National Grid Electricity Transmission Project

EN020026 : Sea Link

ACTEA Submission at Deadline 7

Interested Party: Aldringham-cum-Thorpe Energy Action (ACTEA)

Suffolk Onshore Scheme Abnormal Load Routing Plan

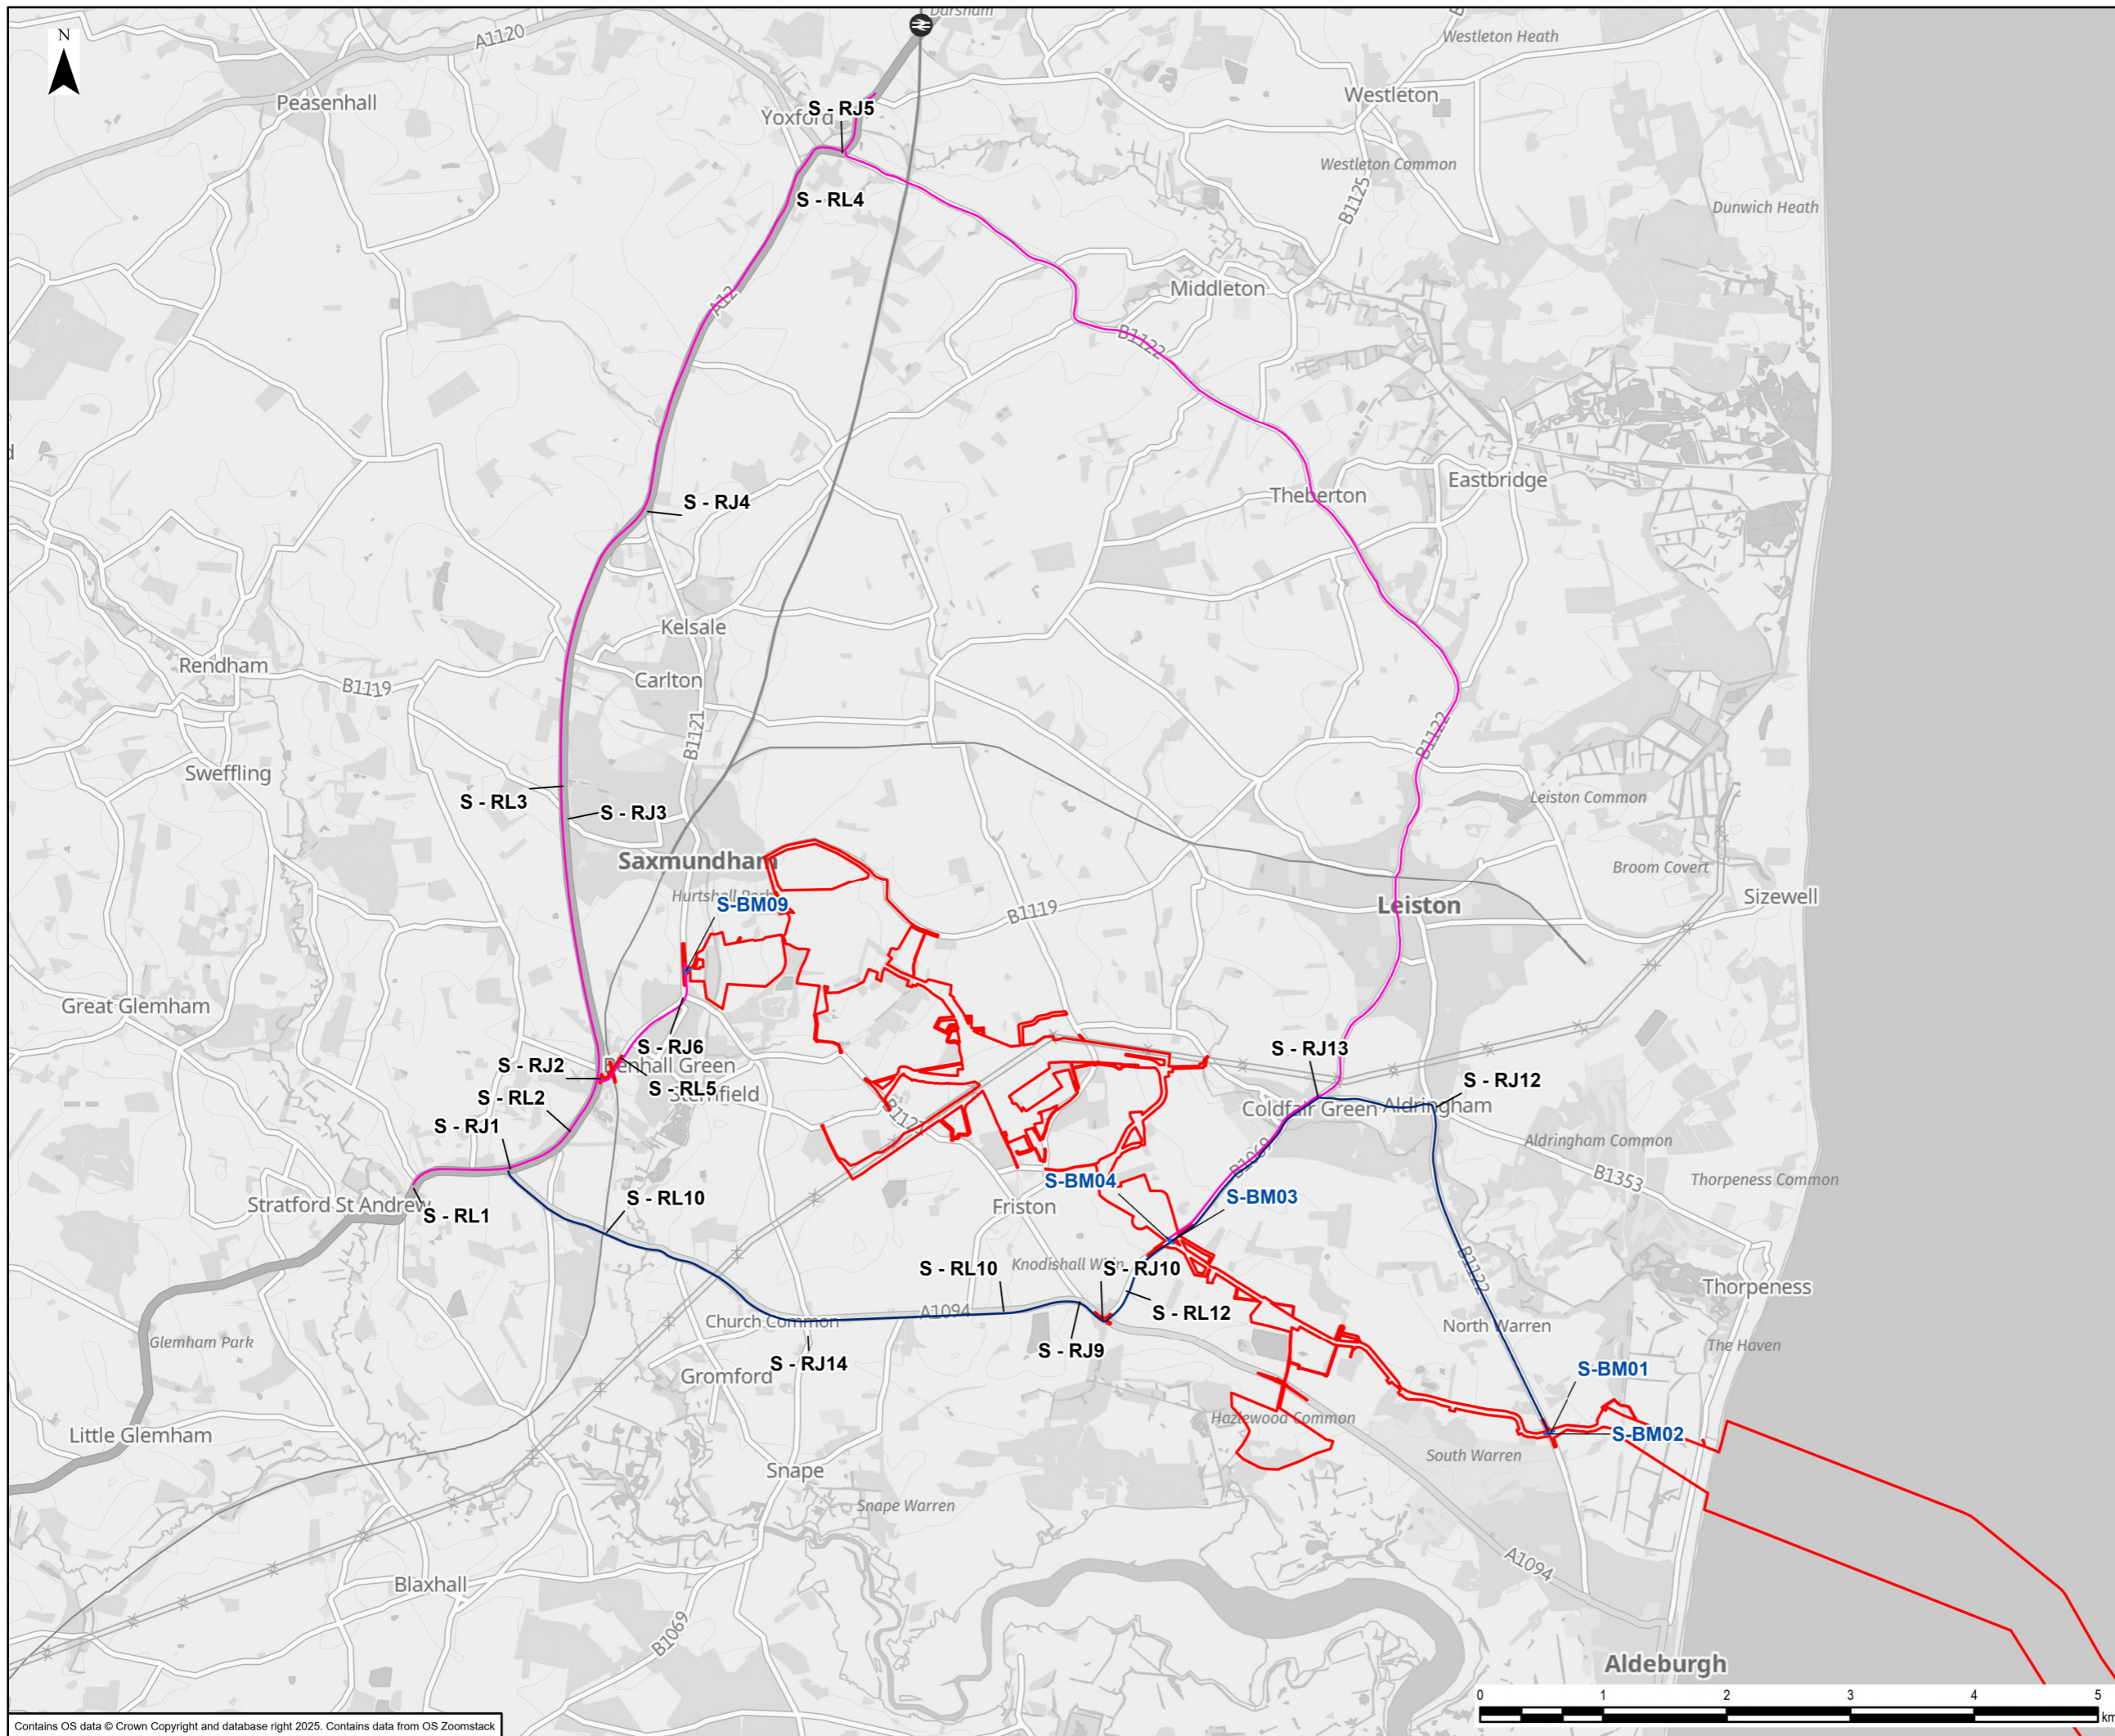
Concerns regarding the use of Aldringham Lane B1353 by Cable Drum Carrier ALL vehicles and a number of 'Smaller construction vehicles' remain unresolved at Deadline 7.

The Applicant had expressed its confidence that B1353 Aldringham Lane is suitable for cable drum movements, despite having previously acknowledged in 6.4.1 of 7.5.1.1: 'Outline Construction Traffic and Management and Travel Plan – Suffolk' that tight road junction geometry at AC10 / S-RJ13 B1069 through Knodishall village and AC11 / S-RJ12 Aldringham Lane/ Aldeburgh Road junction in the centre of Aldringham village “may necessitate junction widening at one or both junctions”.

Evidence to allay fears that nearby dwellings might be impacted by such widening at one or both of junctions AC10 / S-RJ13 B1069/B1353 and AC11 / S-RJ12 B1353/B1122 has not yet been published.

It is conceivable that such widening could impact negatively on nearby dwellings. Therefore, given that no alternative route to delivery site has been proposed, evidence is required in support of the Applicant's conclusions prior to ExA's final report to the Secretary of State.

ACTEA has suggested at Deadline 6 that this matter could be resolved by the Applicant publishing indicative swept path diagrams illustrating cable drum carrier paths at AC10 / S-RJ13 B1069/B1353 junction) and at AC11 / S-RJ12 (B1353/B1122 junction) superimposed over a map of the existing roadway and roadside features in those localities.
